**WEST SUSSEX COUNTY COUNCIL
PLANNING SERVICES CONSULTATION**

SUBJECT: CM/20/17/PL-Change of use from storage (B8 Storage & Distribution) to industrial use (B2 General Industry) for manufacturing, storage & distribution of concrete products. This application is a Departure from the Development Plan.

Unit H21, Rudford Industrial Estate, Ford Road, Littlehampton, BN17 5QX

LAYOUT PLAN FOR
UNIT H21
RUDFORD INDUSTRIAL ESTATE
FORD
WEST SUSSEX

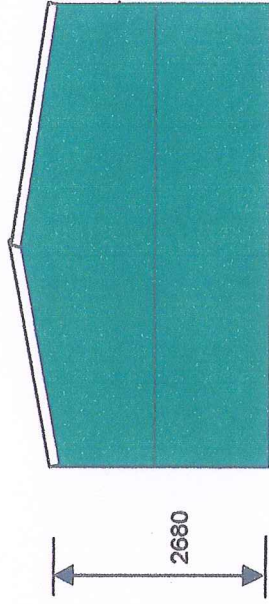
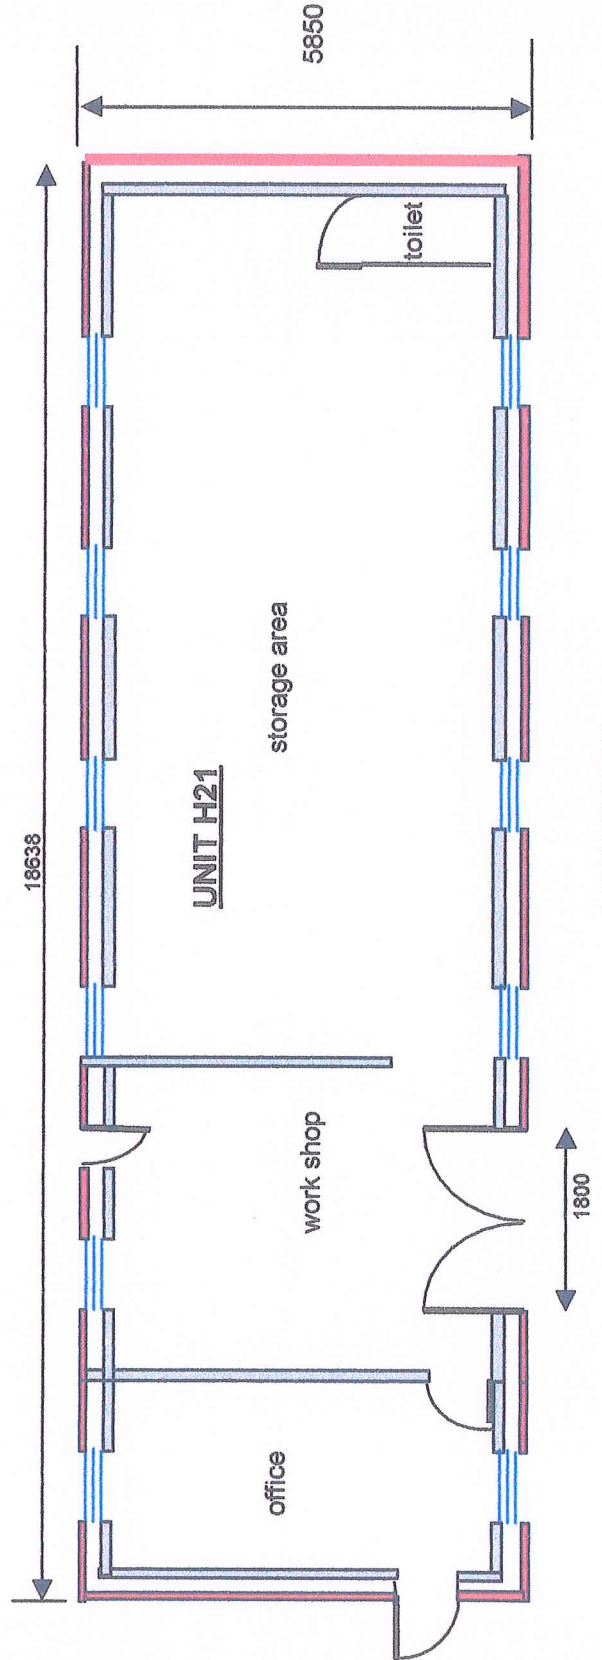
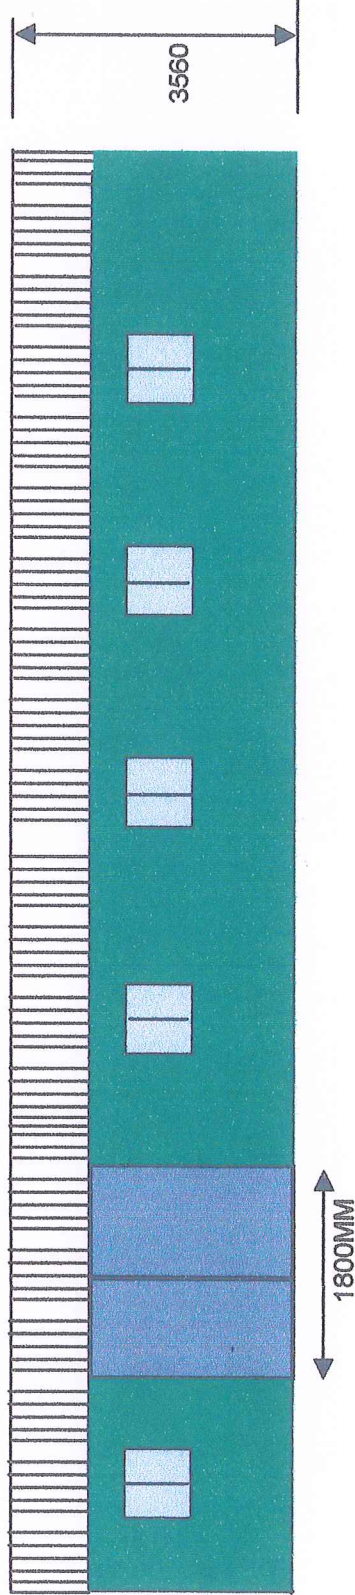
The proposed parking shown is considered acceptable for the proposed uses and in accordance with requirements. The LHA are not aware of that the previous use resulted in excess parking onto Ford Road; it is considered unlikely that there would be an increase in on-street parking as a result of this proposal.

No part of the development shall be first occupied until the car parking has been constructed in accordance with the approved site plan. These spaces shall thereafter be retained at all times for their designated purpose.
